From: Nolan, Chris <Chris.Nolan@lancashire.gov.uk>
Sent: 18 January 2018 09:01
To: Harriet McCartney; planning
Cc: LHS Customer Service
Subject: D3.2017.1127 - Field View Ribblesdale Avenue Clitheroe

Planning Application No: 3/2017/1127
Grid Ref: 374168 442623

Proposal: Proposed extension of a single storey wrap around side and rear extension. Construction of two dormer roof windows as part of the loft conversion. Conversion of a detached garage to granny annexe.

Location: Field View Ribblesdale Avenue Clitheroe BB7 2HZ

Client	Mr and Mrs Sutherland
Job Title	Proposed Garage Conversion at Field View Ribblesdale Avenue Clitheroe
Drawing Title	Proposed Granny Annexe Plans and Elevations
Scale	1:100 @ A3
Date	June 2016
Drawn	NE

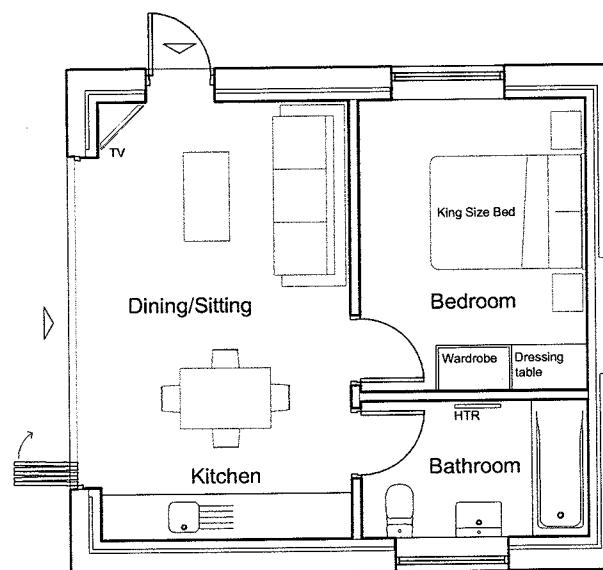
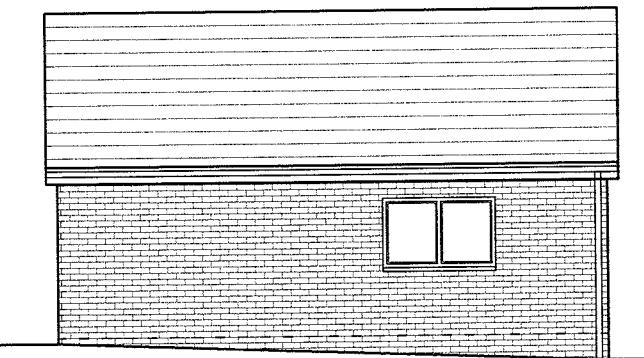
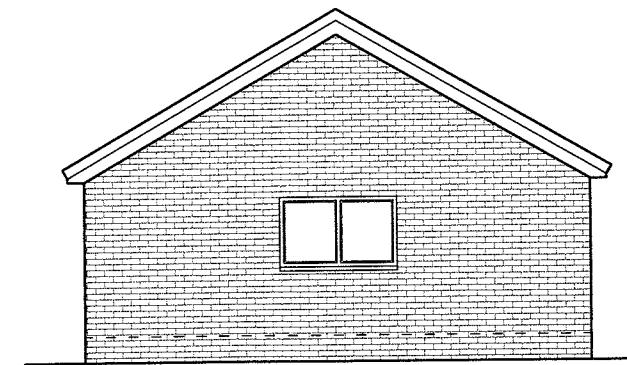
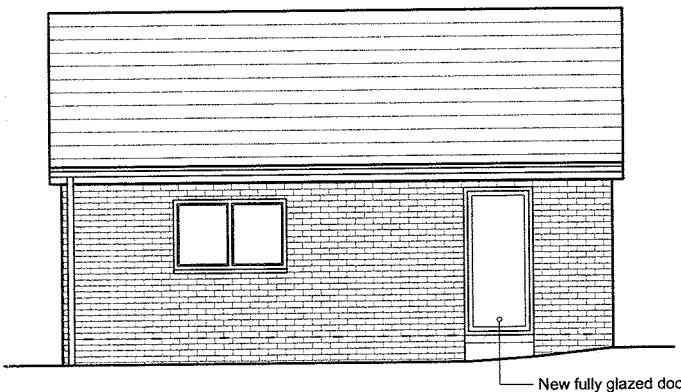
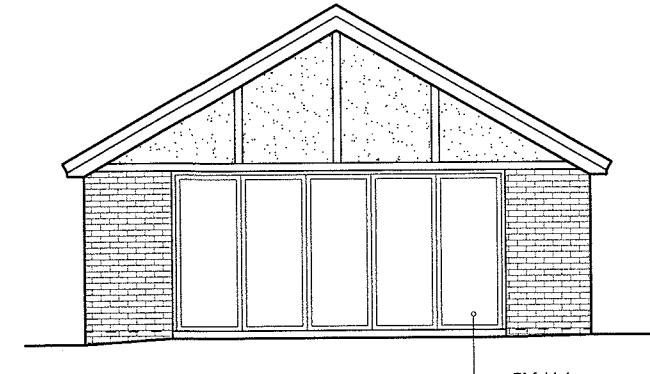
The conversion of the garage to a granny annex would have an impact on the parking as this could be assessed as a separate dwelling whilst also reducing the present parking provision at the property. If the annexe is to be a separate dwelling then as a single bedroom unit we would be looking for a dedicated parking space for this provision and such would need to be independent of other provisions in that it could be used without the residents at the main building needing to move their vehicles to allow access and egress. This could be avoided by conditioning that the annexe is uses by a family member. Unless indicated differently I would presume this to be the case and request that this is conditioned in the permissions for the development.

The removal of the garage from the present parking provision will still need to be addressed and for that reason I would request that the applicant submits a site plan indicating the parking provisions once the development is completed. Please note that these provisions should include provision for three vehicles along with space to turn vehicles so that all traffic can enter and leave the site using forward gears.

1. The converted garage hereby approved shall only be used ancillary to the enjoyment of the existing household and shall not be used by way of sale or sub-letting to form separate residential accommodation. Reason: To avoid the creation of separate dwellings which may be substandard in terms of parking provision and/or vehicular manoeuvring area.
2. The layout of the development shall include provisions to enable vehicles to enter and leave the highway in forward gear and such provisions shall be laid out in accordance with the approved plan and the vehicular turning space shall be laid out and be available for use
